# Rezoning Transportation Analysis

Petition Number: 2020-123

## Revision Log:

| Date       | Description       |
|------------|-------------------|
| 09-11-2020 | First Review (KP) |

RZ  
 1

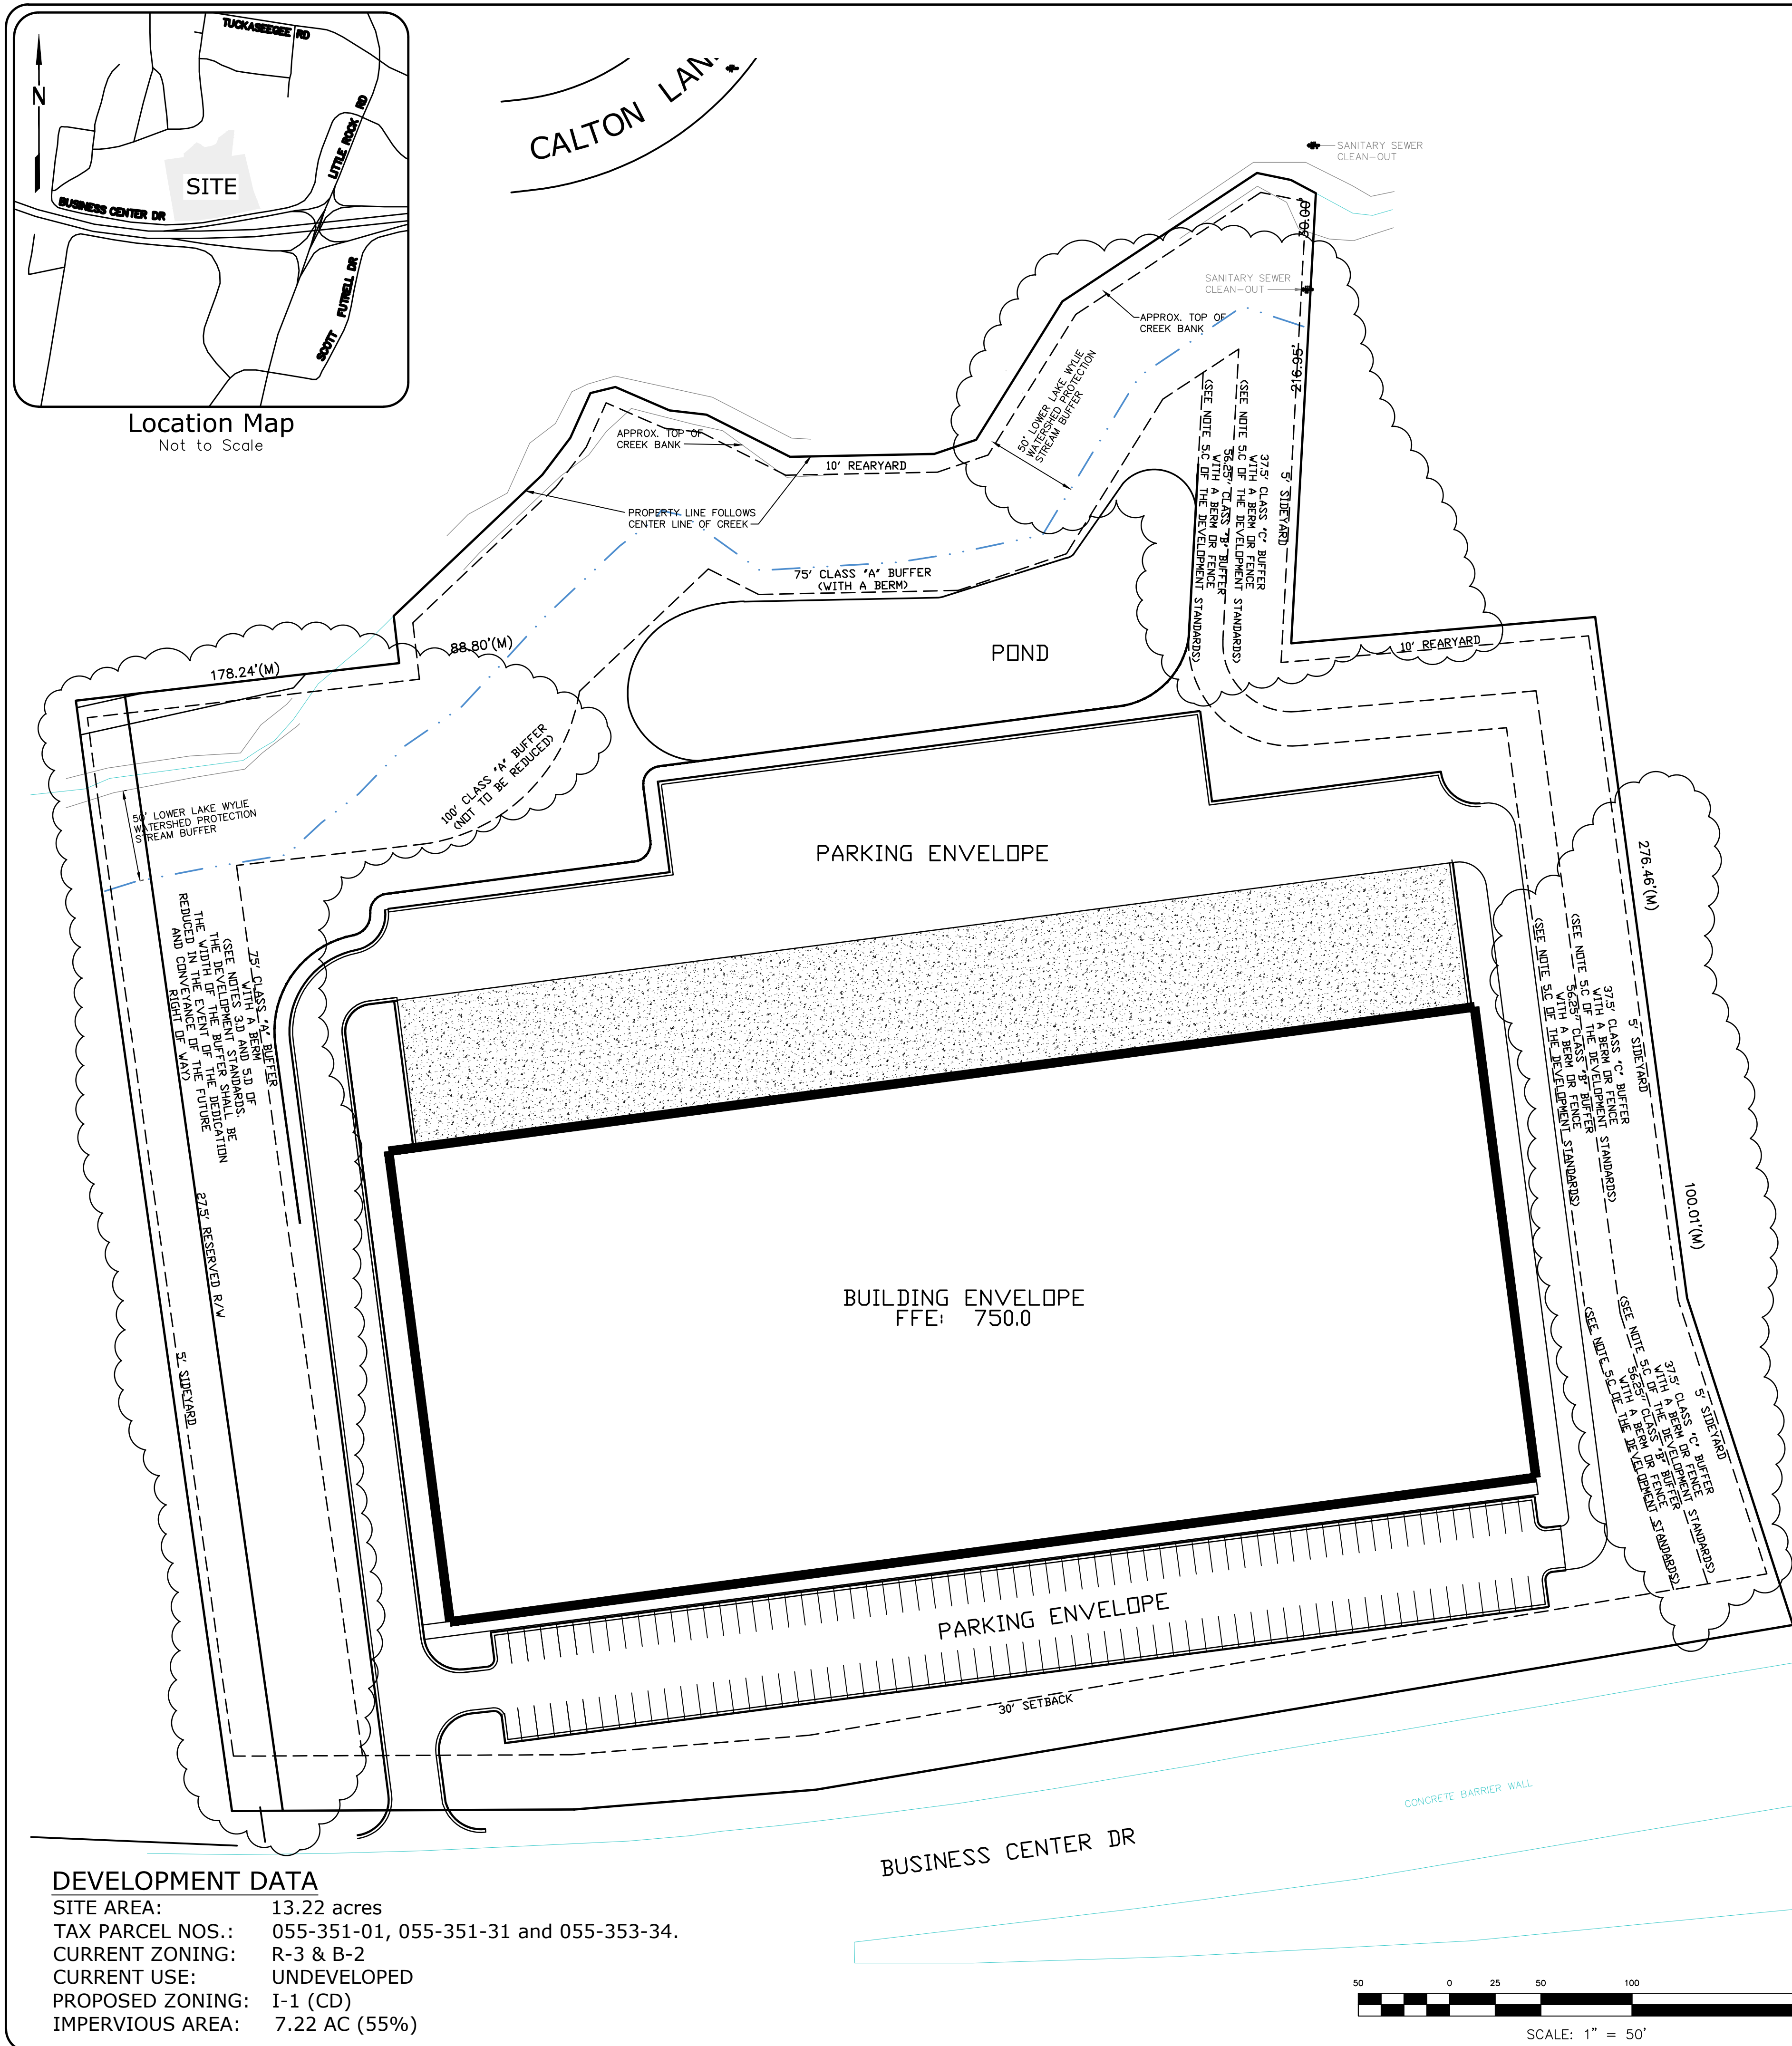
2. Revise the site plan and conditional note(s) to commit to dedicate right-of-way 2-ft back-of-sidewalk on Business Center Drive, labeled and dimensioned from the road centerline.

3. Revise the site plan and conditional note(s) to commit to construct an 8-foot planting strip and a 6-foot sidewalk per Charlotte WALKS, labeled and dimensioned from the road centerline.

4. Revise the site plan and conditional note(s) to commit to constructing a public street to the west of the property, constructed relative to U-06, local industrial section, in the Charlotte Land Development Standards Manual.

- Revise the site plan and conditional note(s) to include the street's cross section and label the street as "public".
  - At least one access driveway that connects to this new public street is needed.
